DECISION DELEGATED TO HEAD OF PLANNING

Application No: H04-0585-25 **Applicant:** Bear Guru Property Partners Limited

Proposal: Conversion of two-storey single dwelling into three self-contained residential units including internal alterations - Retrospective

Location: 11 A, B & C Church Street (Formerly 11 Church Street) Donington Spalding

Drawing Number:
BGPP/11CS/102A

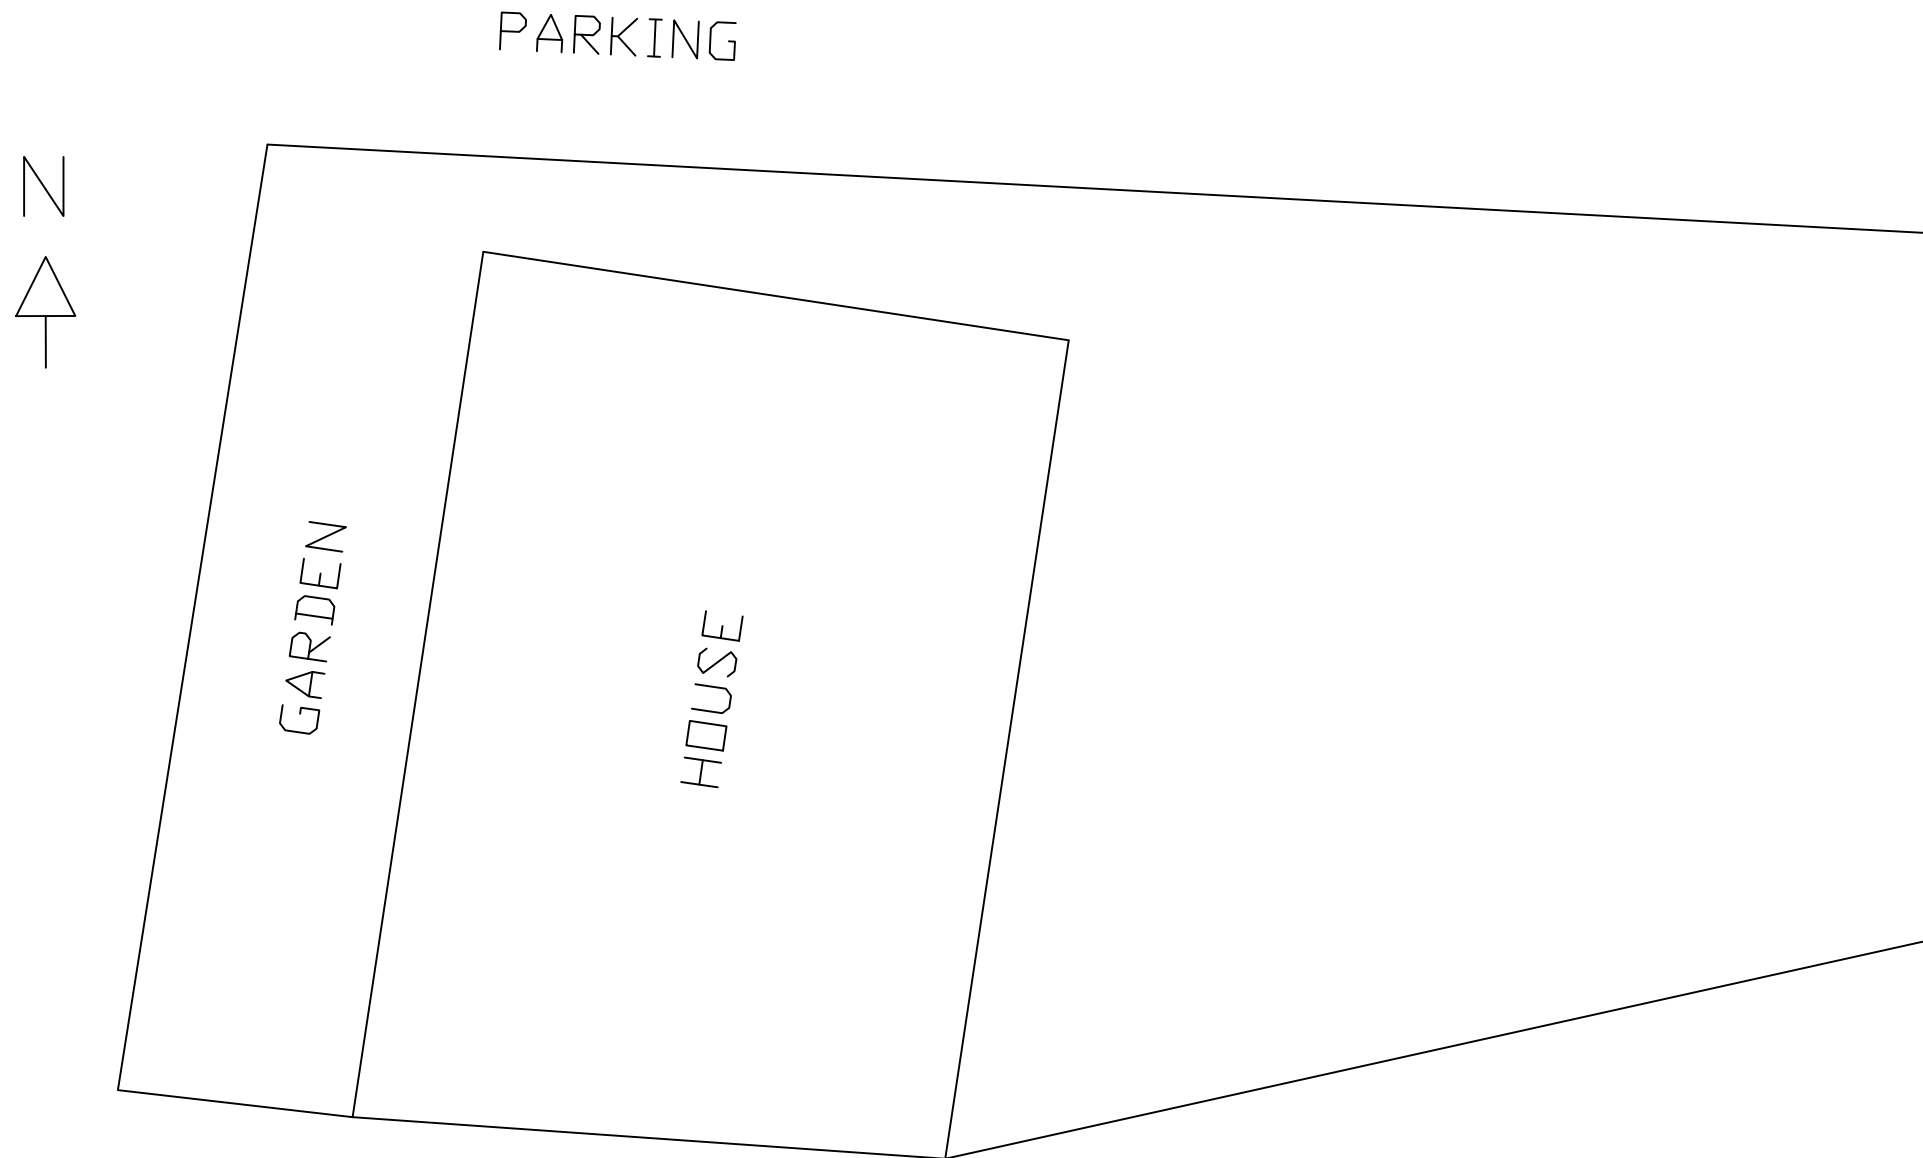
In terms of part 4, the submitted plans do not indicate where space is allocated for refuse storage. There is reference to dedicated bin storage areas within the submitted application form and the Design and Access Statement; however, the plans do not clarify where these areas are. Flat 11A does not have any external amenity space and as such it is even more unclear where the dedicated bin storage area is for this dwelling. There is potentially room at the side of the property for this, though this would encroach on the already limited amenity space for occupants. The proposal potentially has the capacity to accord with part 4, however, insufficient information has been provided to confirm this.

In terms of part 5, the submitted plans show 2 parking spaces for Flat 11B and 2 parking spaces for Flat 11C at the rear of the site. The plans show an area of 'parking' at the side of the property for Flat 11A, within the private access road that is taken from Church Street. This land is outside the applicant's ownership. The spaces at the rear of the site would comprise tandem parking spaces. As three flats are proposed, it is not considered appropriate for occupants to need to tandem park with occupants from another flat. Therefore, whilst there is potentially room for 4 spaces within the site, Flat 11A would need to park on roads near to the site. Lincolnshire County Council's Highways Team have not raised objections to the proposals in terms of highway safety. The team have recognised that occupants of Flat 11A might need to park outside of the site, however, this is not considered to pose a significant highway safety risk in this case. The private access road to the site from Church Street is considered to be wide enough not to block a safety passageway for other vehicles. If vehicles cannot park on the private road, occupants might need to park on Church Street, which does not feature double yellow lines on the area near to the site. As such, the proposal is considered to accord with part 5.

In terms of parts 7 and 8, it is not considered that occupants would be provided with an adequate standard of residential accommodation or garden space. For example, Flat 11C features approximately 36sqm of internal floorspace and Flat 11B features approximately 34sqm. The nationally described space standard requires single storey flats to be provided with at least 37sqm of internal floorspace, including built in storage. This recommendation is for flats that would contain only one occupant. As such, insufficient internal living space is proposed for the flats. Flat 11A is spread over two floors and as such, it is considered that this flat should be provided with at least 58sqm. This is achieved in this case as approximately 59sqm of floorspace is proposed. It is also considered that insufficient garden space is proposed for Flat 11B and Flat 11C on the ground floor as the garden has already been subdivided. No outdoor amenity space is proposed for Flat 11A which is located mostly upstairs. Therefore, the proposal does not accord with parts 7 or 8 of the policy.
